Your Ref: OWPC23826
Our Ref: FP/139/19/OUT 23-06-2019
Please ask for:
Maria Tomalova

Outline application with all matters reserved for the erection of 1 No. dwelling.
Land south of garage compound & East of 12 Alfriston Close Felpham

Thank you for your internet representation made on 29th July 2019 which has been recorded as '**an objection**' with the comments as follows:

Land East of 12, Alfriston Close, Felpham, West Sussex, PO22 6QB

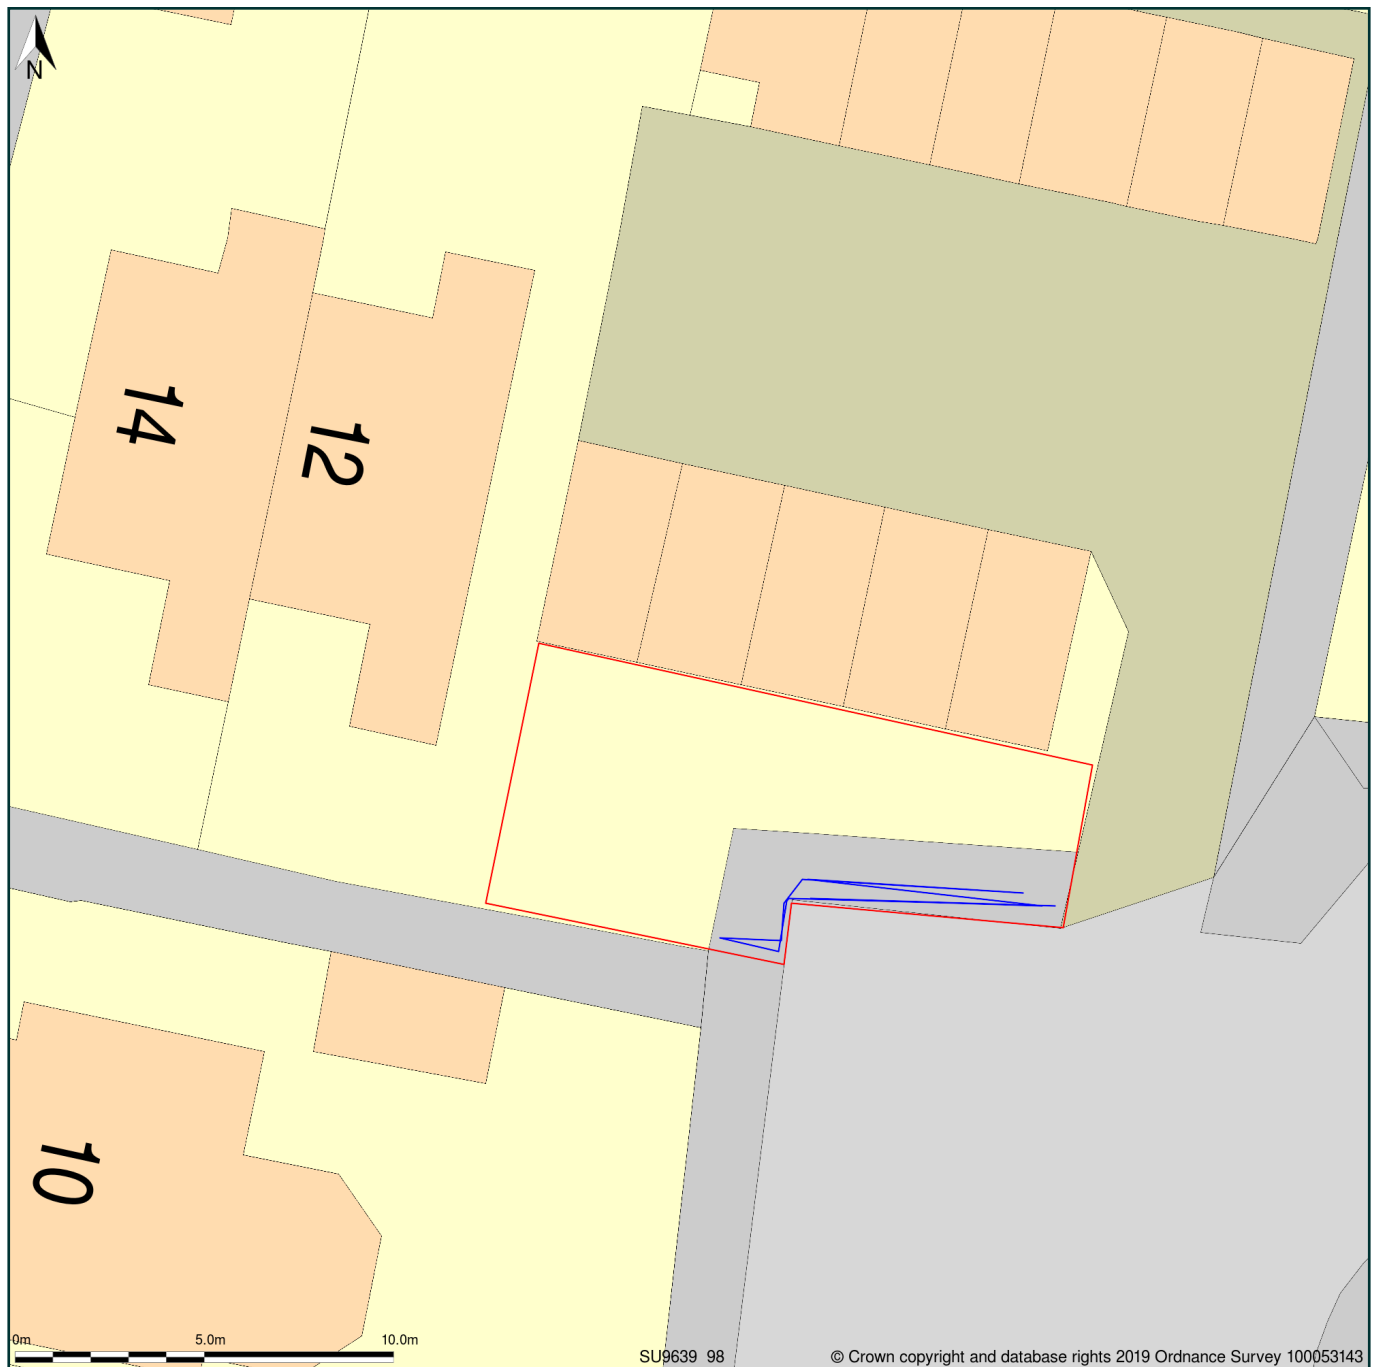
The loss of part of the pavement as outlined in the block plan, restricting access for residents and disabled access.

There is a street light on this plot of land which serves the pavements for the following properties: 12-14 Alfriston Close and 6-9 Fittleworth Drive as well as the garage compound.
